**RESPONSES TO THE WRITTEN QUESTIONS OF THE EXAMINING AUTHORITY
FOR DEADLINE 2**

**RWE Renewables UK Solar and Storage Limited
for an Order Granting Development Consent for
the Byers Gill Solar Project**

PINS Reference No: EN010139

SHEET 11 OF 13

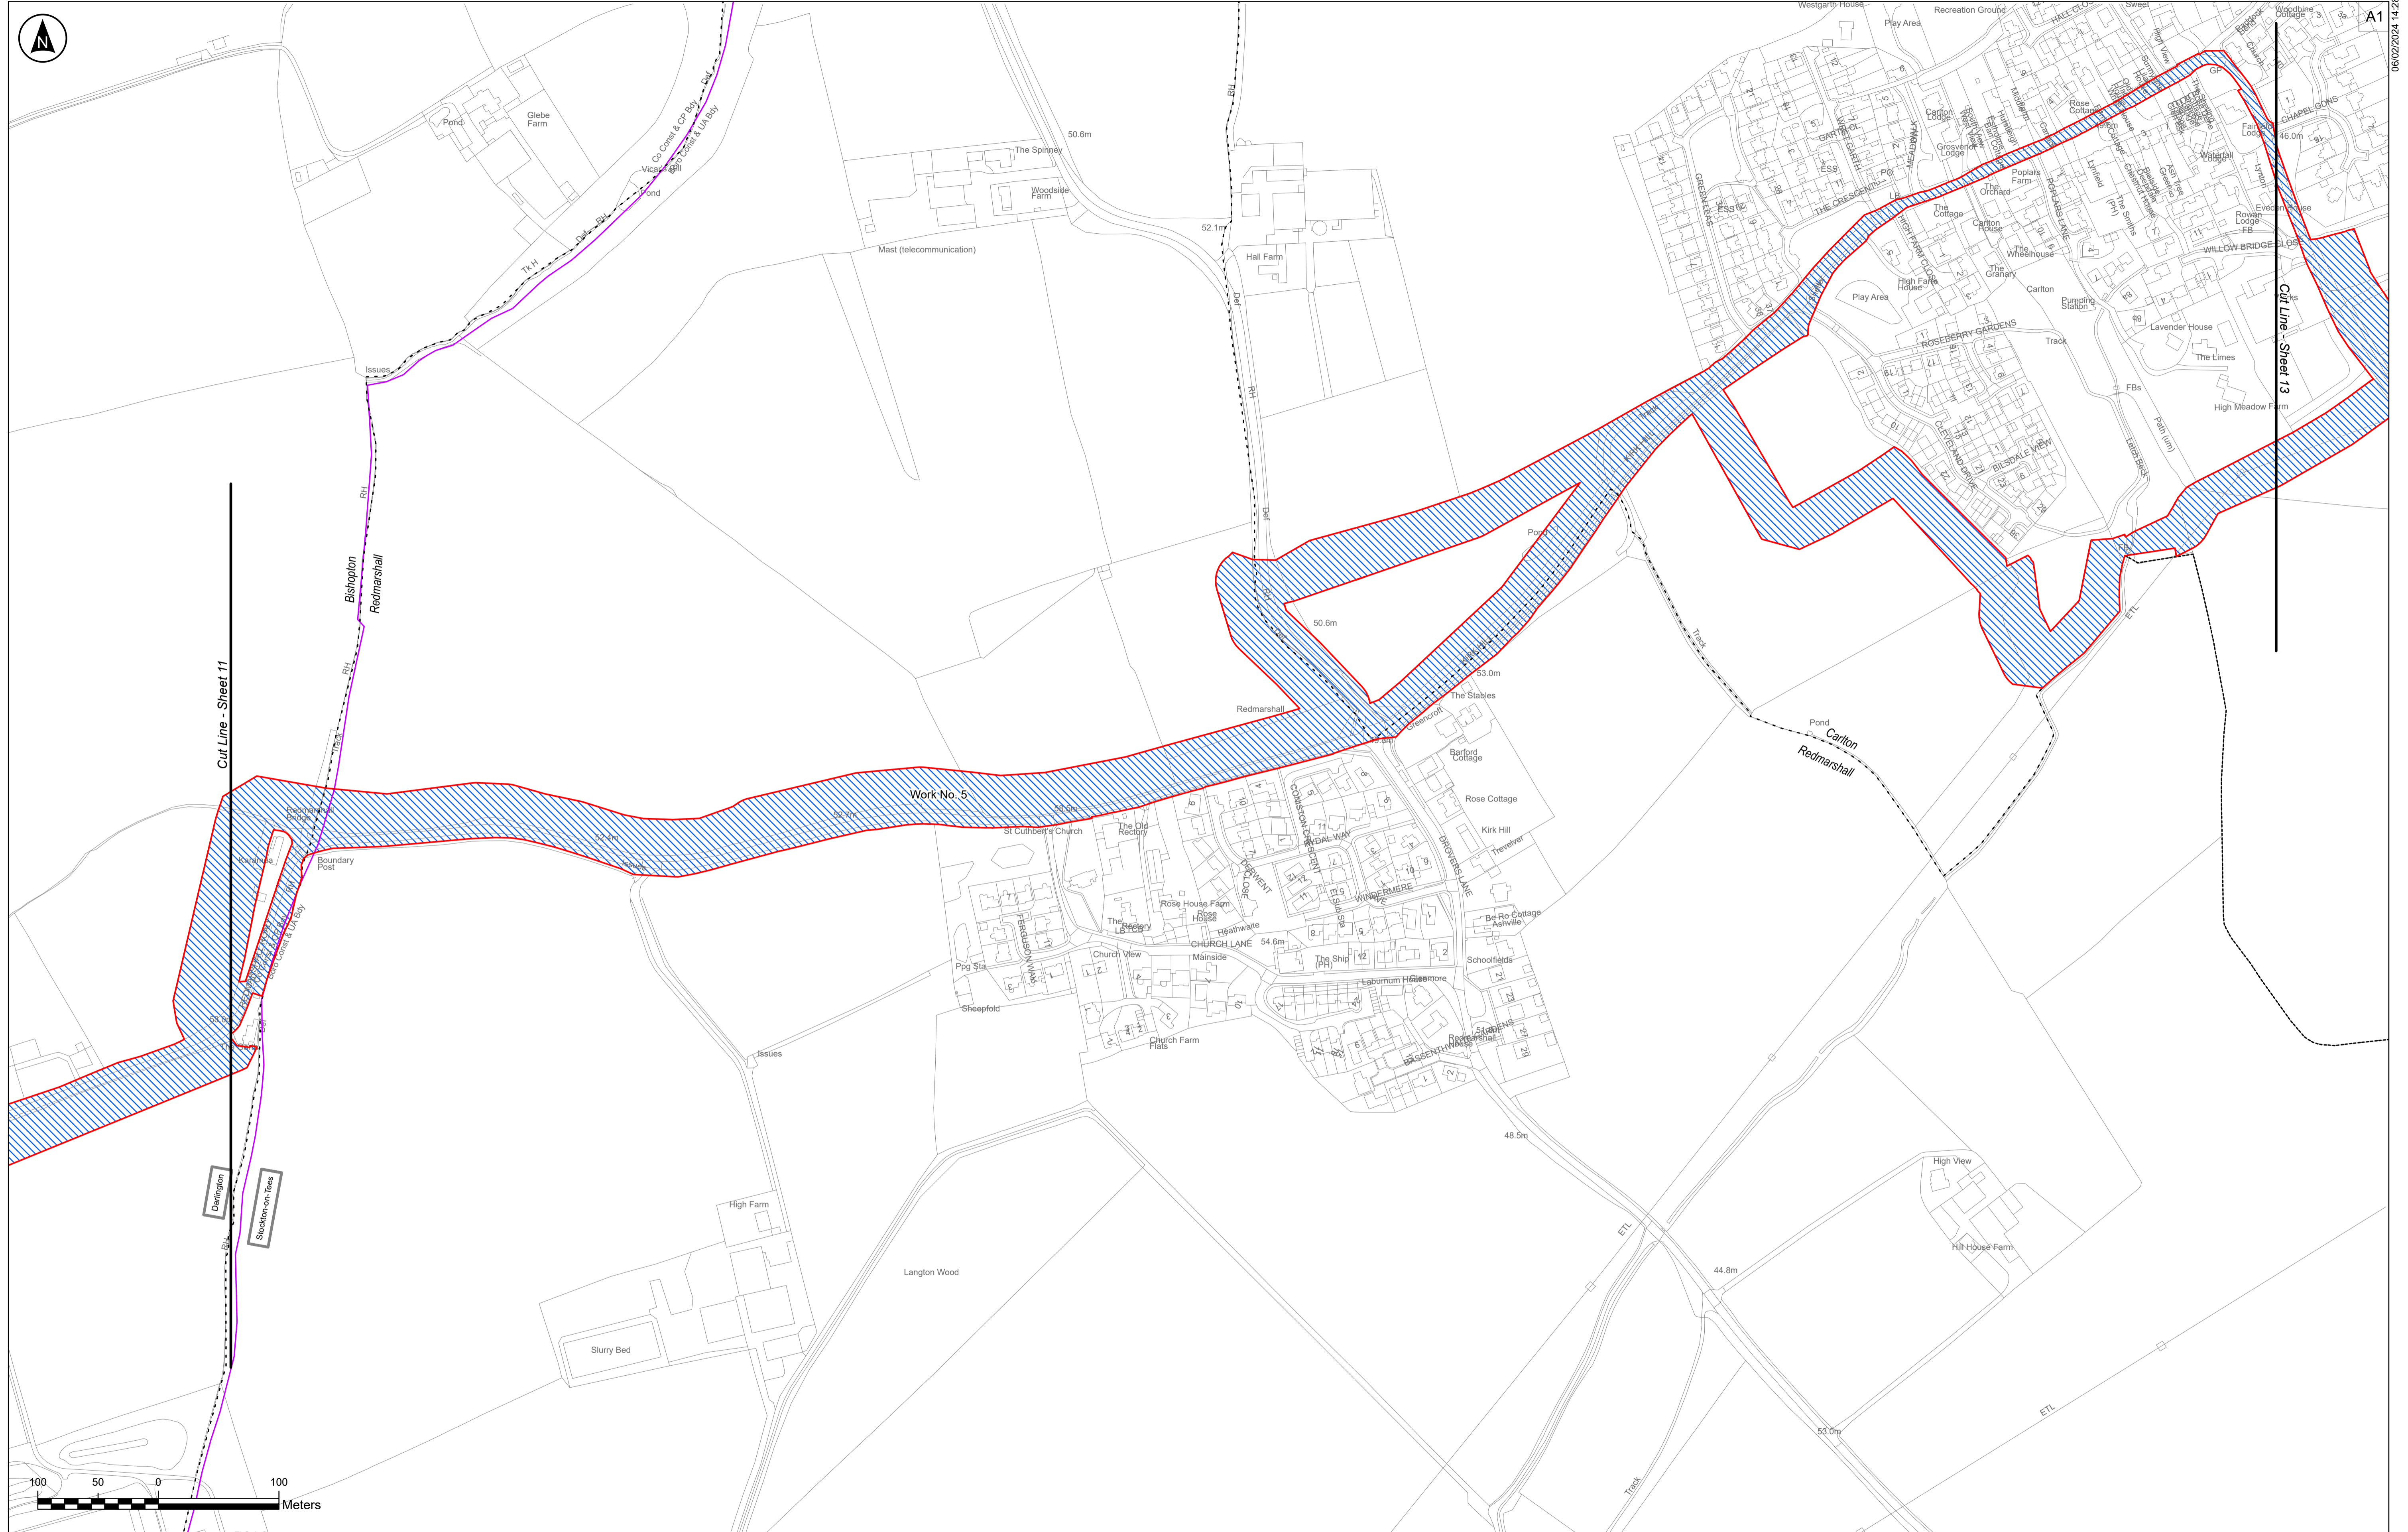
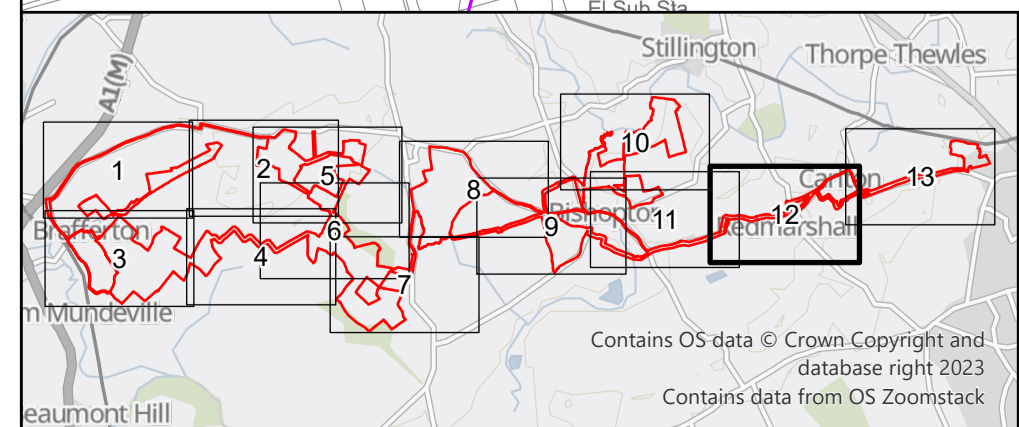
ExQ1	Question to:	Question:	Historic England response
HEN.1.6	<p>DBC Historic England Applicant</p>	<p>The Environmental Constraints Plan [APP-057], in Fig. 2.19 and the Works Plans [AS-013] in Sheet 11 of 13 show that proposed works No. 5 - Cable 132Kv will be conducted in close proximity to the scheduled monument motte and bailey castle. Can the Applicant please provide some further information and confirmation that works will be sensitive to the scheduled monument motte and bailey castle and how and where in the DCO works have been secured in order to protect the integrity of an scheduled monument. Can DBC and Historic England please confirm that they are in agreement with the Applicant's proposed approach?</p>	<p>The applicant contacted Historic England prior to the application being submitted with a query about this.</p> <p>It is our understanding that the proposed works will be undergrounded and are outside the boundary of the scheduled monument. However, we have not seen any final proposed plan.</p> <p>Should the works be outside the monument and underground there would be no impact on the monument, and we would have no concerns.</p>
